From: Amanda Scholes on behalf of Planning.Responses
Sent: 24 June 2019 10:55
To: Planning Scanning
Subject: FW: F/30/18/PL - Drainage comments
Attachments: Barfoots - Sefter Farm Reservoir - Photo 1 - 19th February 2019.jpg; Barfoots - Reservoir - Updated Design - Cundall - 1st February 2017.pdf

Subject: RE: F/30/18/PL - Drainage comments

Thank you for your comments concerning our application to erect multispan polythene tunnels at Wicks Farm, Ford – F/30/18/PL.

SECTION B-B - POND OVERFLOW DRAINAGE PIPE
(SCALE 1:50)

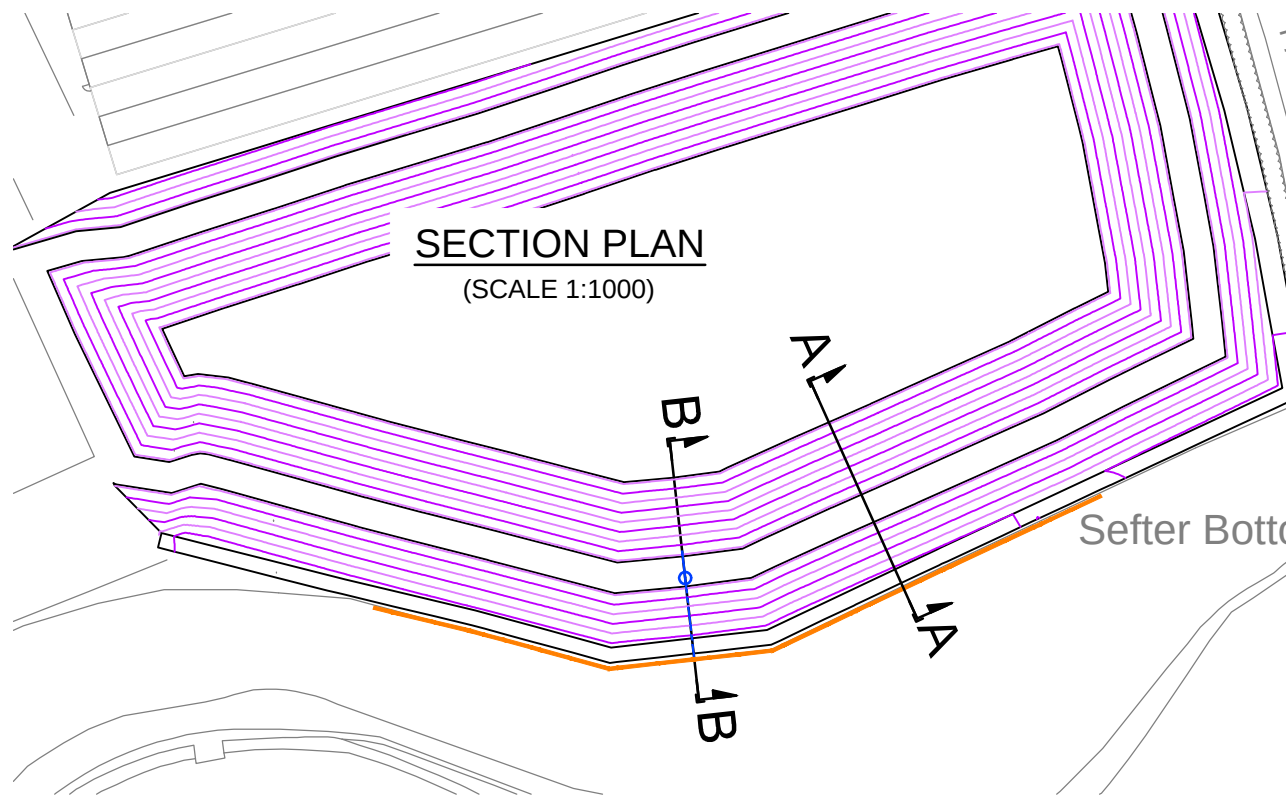
Can you please update the surface water drainage proposals to clearly show this proposed overflow to the ditch system?

I don't yet have the detailed design drawings for the proposed new reservoir at Wicks Farm; so I can't show you the detail of the overflow system; however; I'm attaching a copy of the design plans that we used for the new reservoir at Sefter Farm, Pagham. We completed that build in November 2018 and I've also attached a photo of the completed reservoir.
